Department of Primary Industries

OUT13/23681

Northparkes Extension Project (MP 11_0060) Response to exhibition of Environmental Assessment

Northparkes Extension Project (MP 11_0060) Response to exhibition of EIS Comment by NSW Office of Water

Figure 11: Monitored Groundwater Levels in the vicinity of the Project Area for Observed Regolith

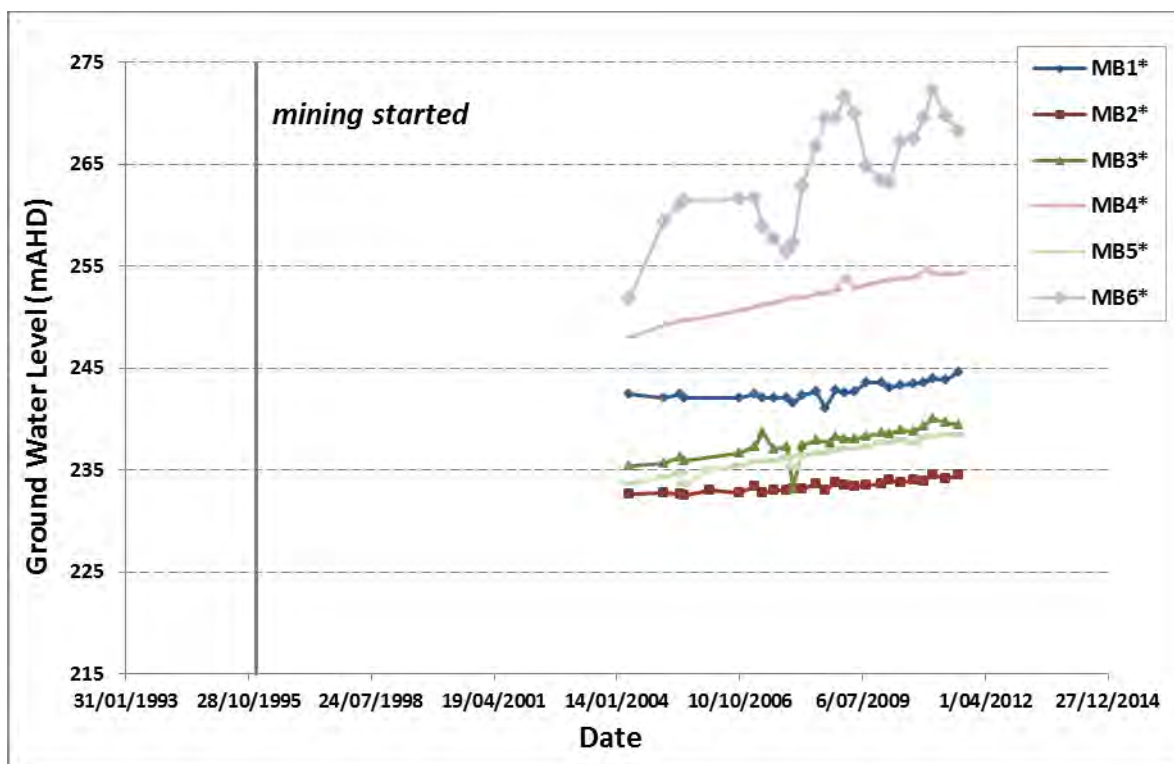
- (iv) Section 4.7: Figures 10, 11, 12 and 13 require adjustment to horizontal 'date' scales to enable hydrograph interpretation. In addition, the astrix marks on Figures 10, 11 and 13 require explanation.

Figure 12: Monitored Groundwater Levels in the vicinity of the Project Area for Observed Regolith and Bedrock

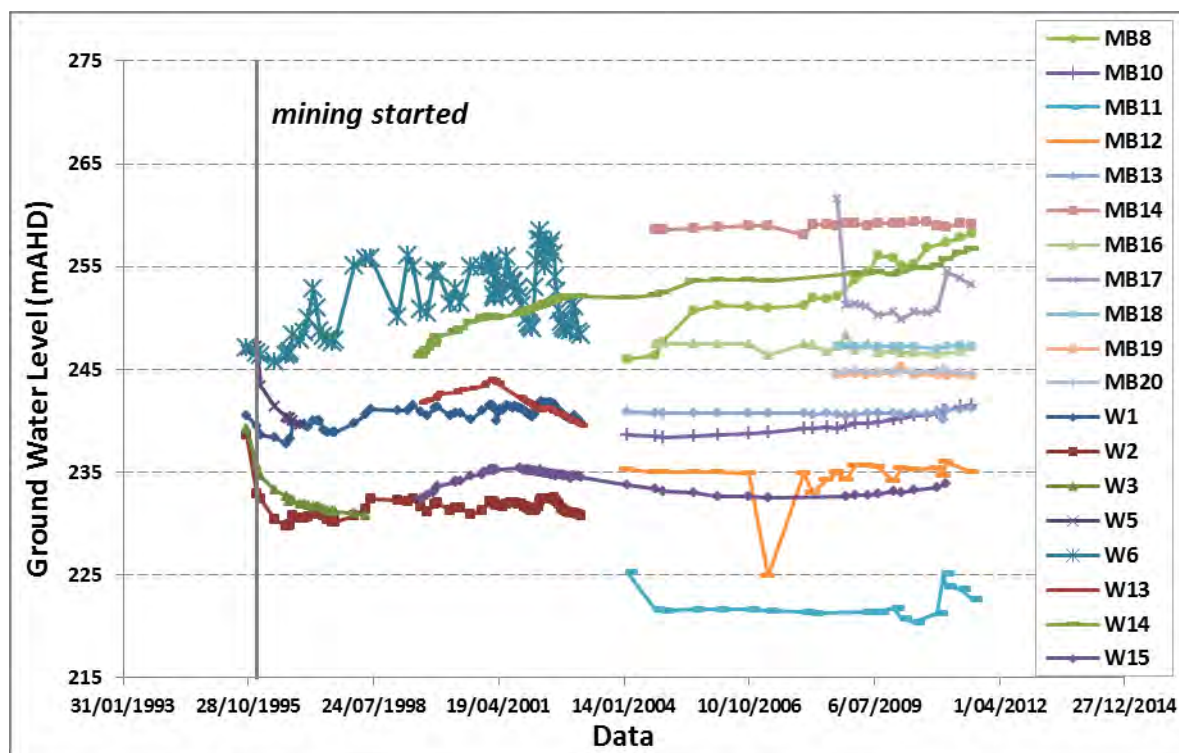
- (iii) Section 4.7: Figures 12 and 13 require an additional hydrograph each to separate hydroplots for the purpose of enabling differentiation of individual bores.
